City of Portland, Maine - Building or Use Permit

Permit No: 06-0415	Date Applied For: 03/29/2006	CBL: 186 C033001
------------------------------	--	----------------------------

Proposed Use: Single Family Home/ Build a 6' x 8' mud room	Proposed Project Description: Build a 6' x 8' mud room
--	--

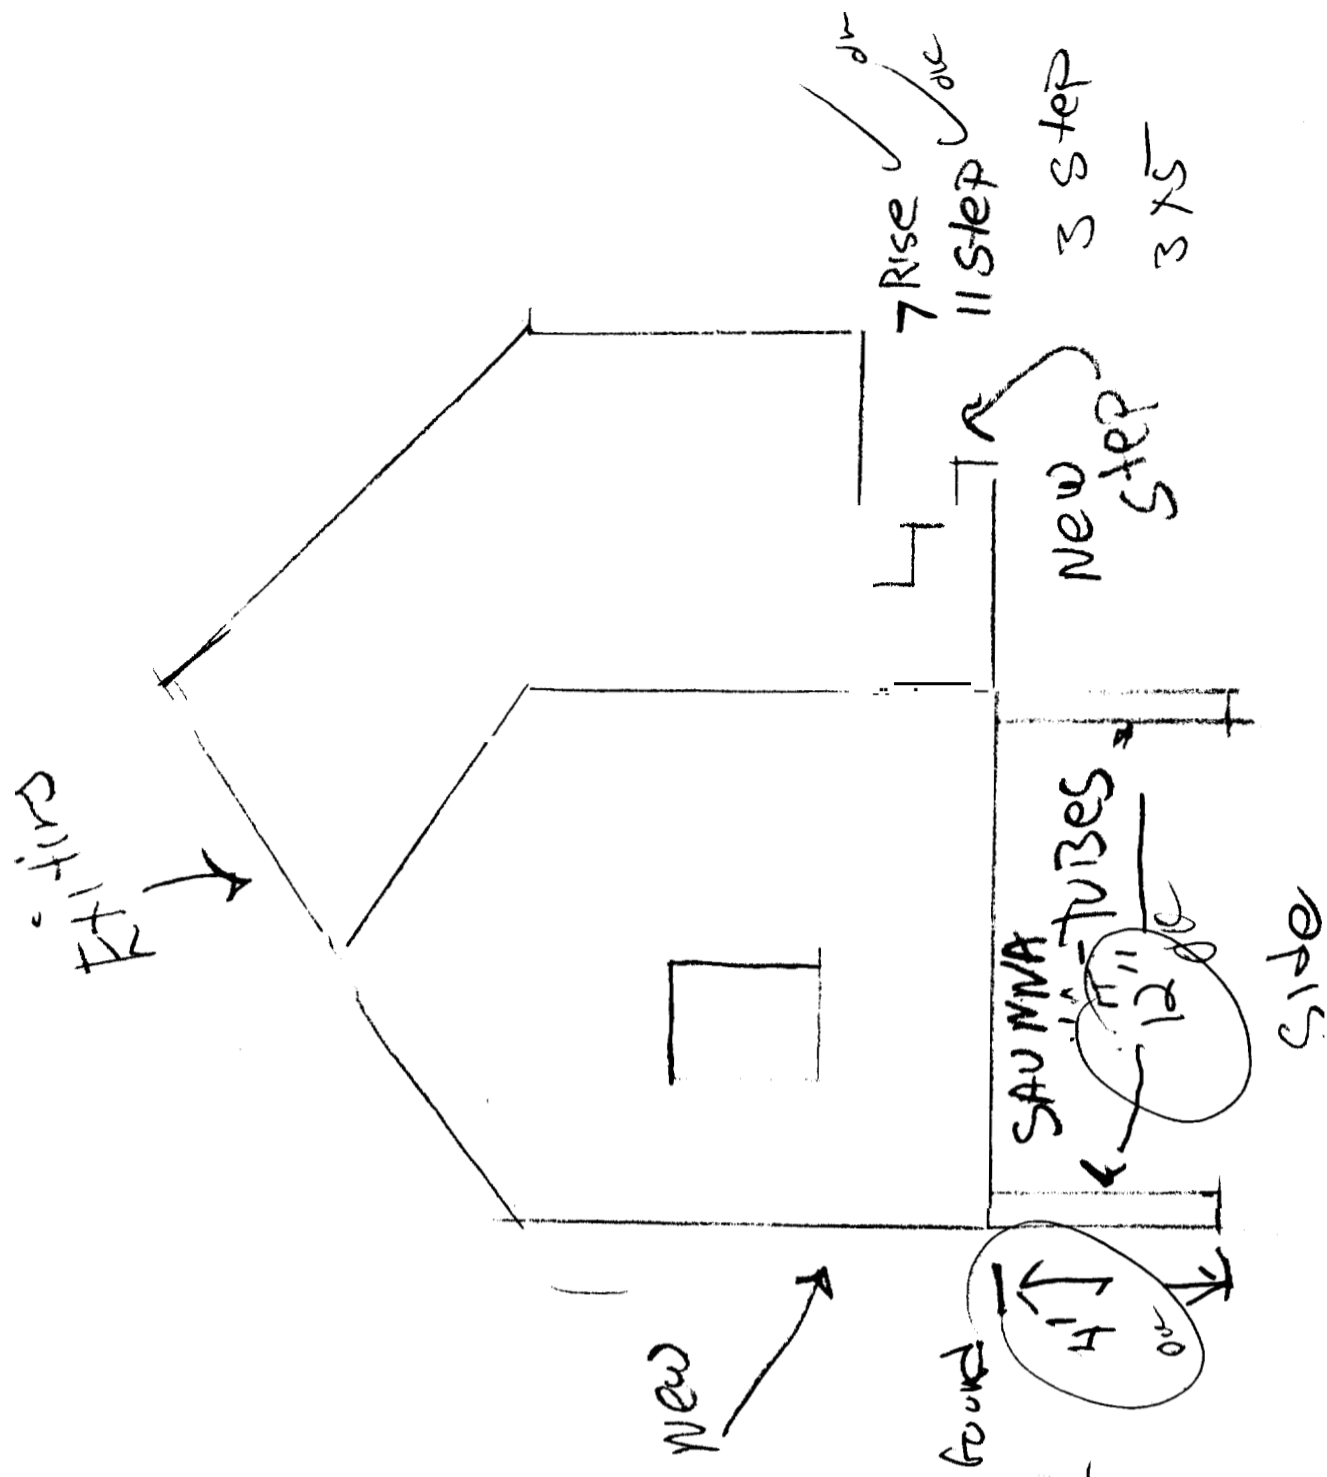
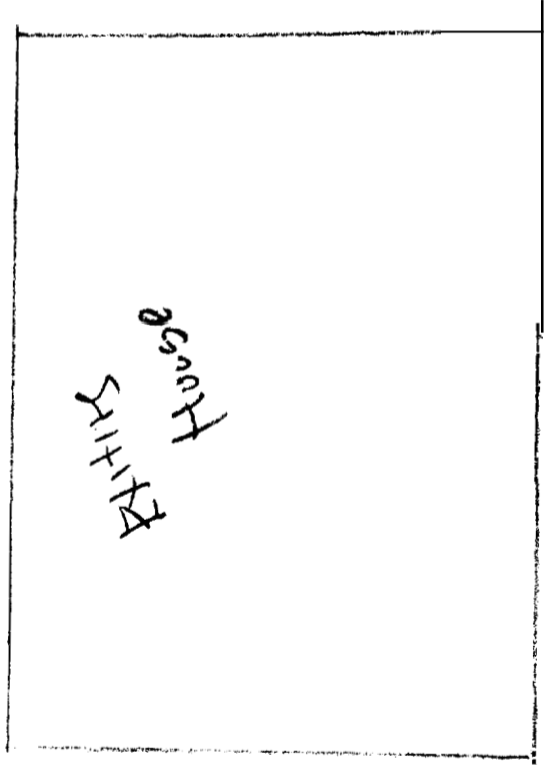
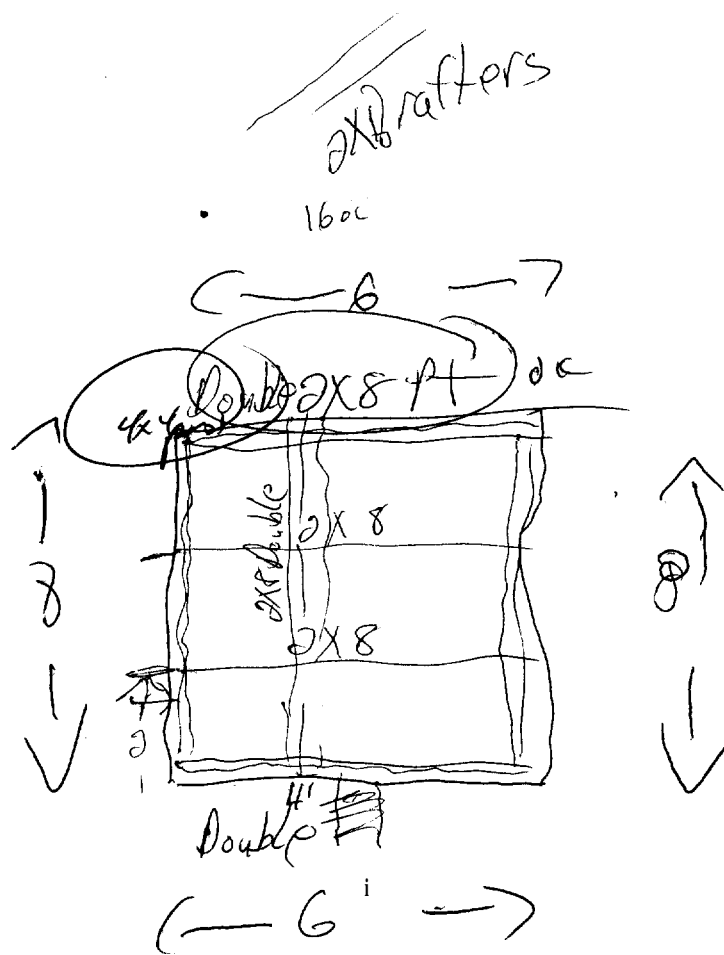
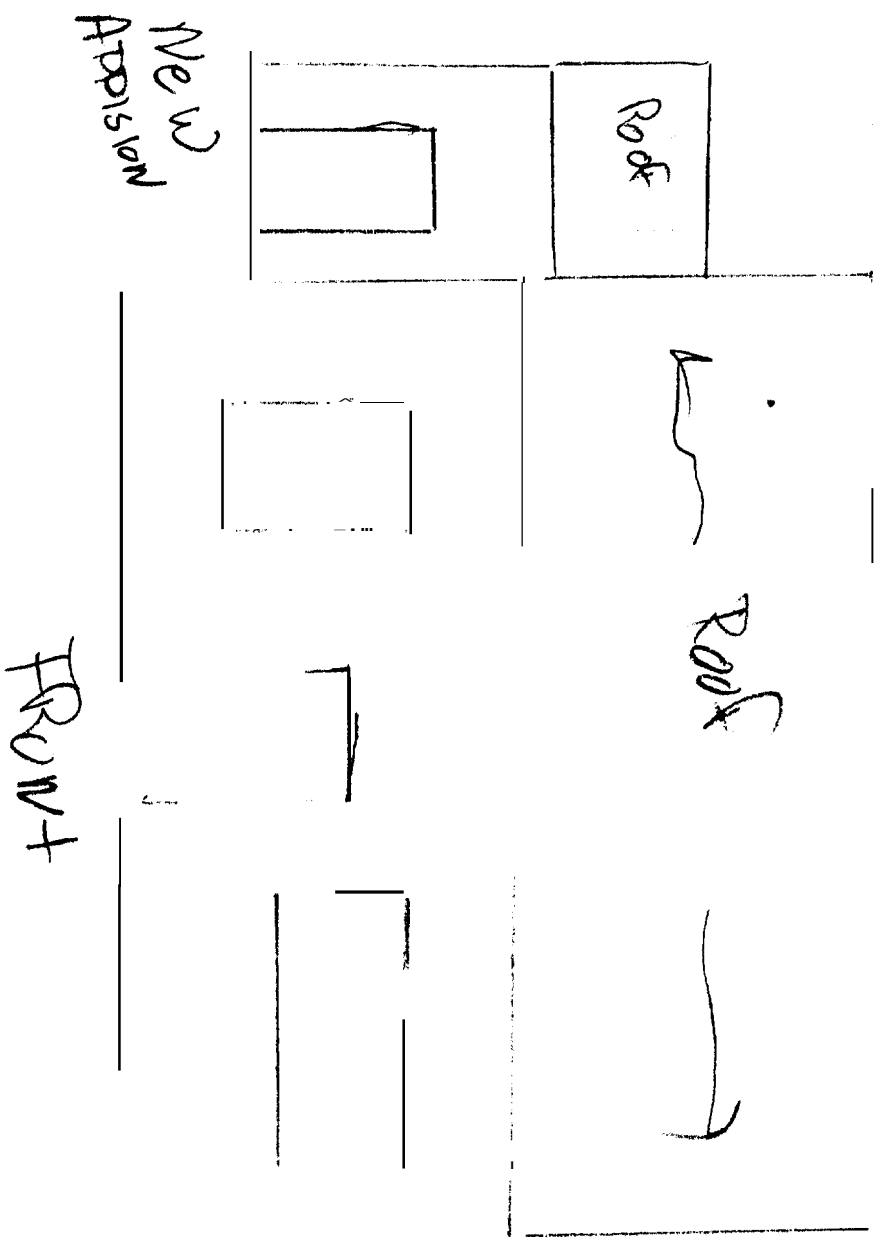
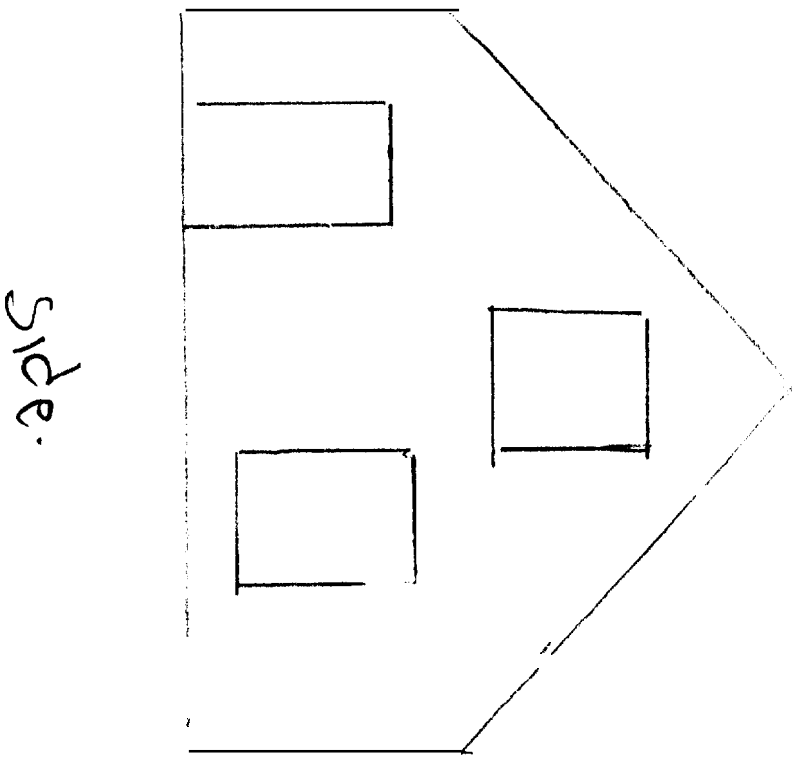
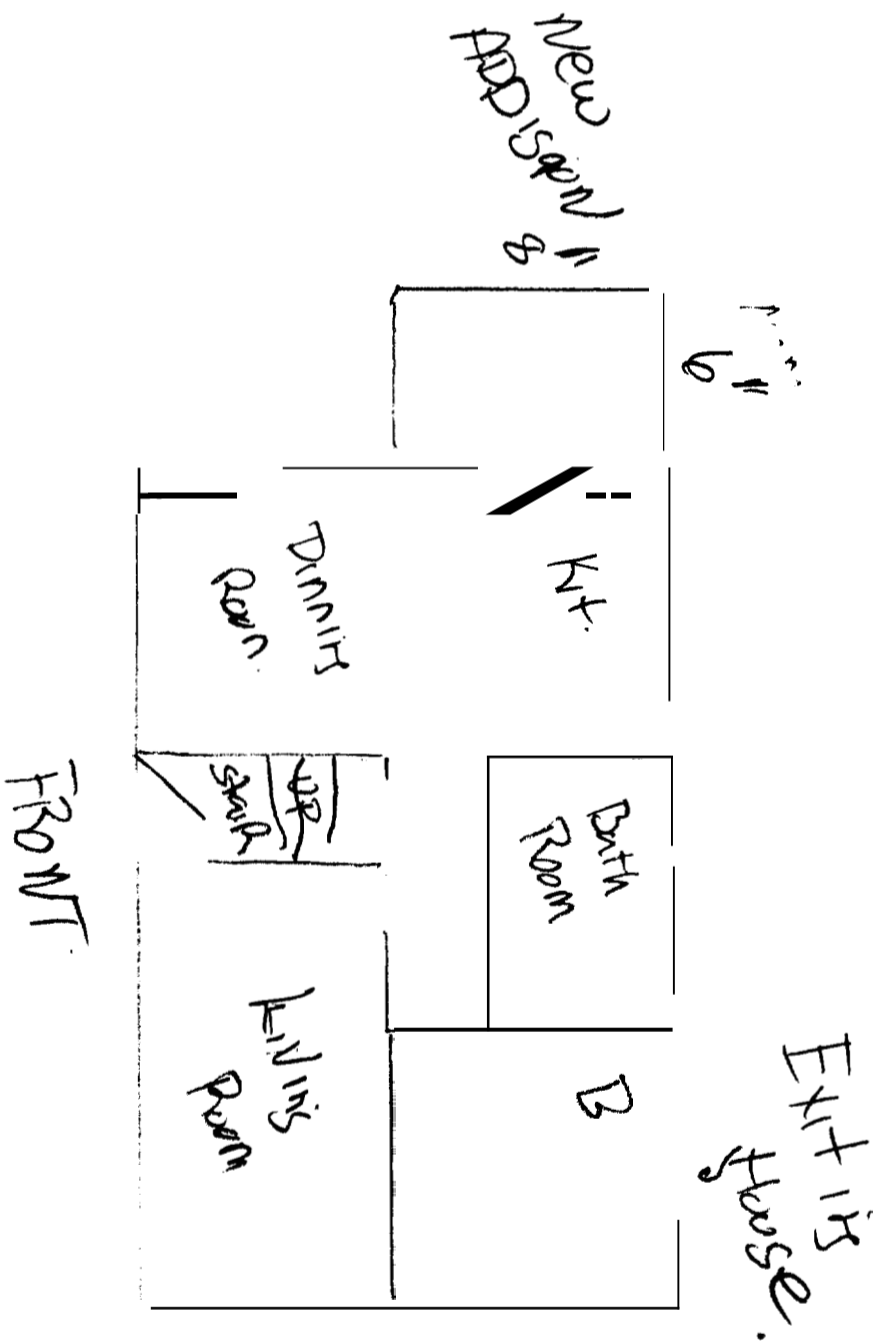
Comments:
4/28/2006-tm: called owner Ken Cooledge and left a message on machine that more precise framing plan is needed before the permit can be issued.
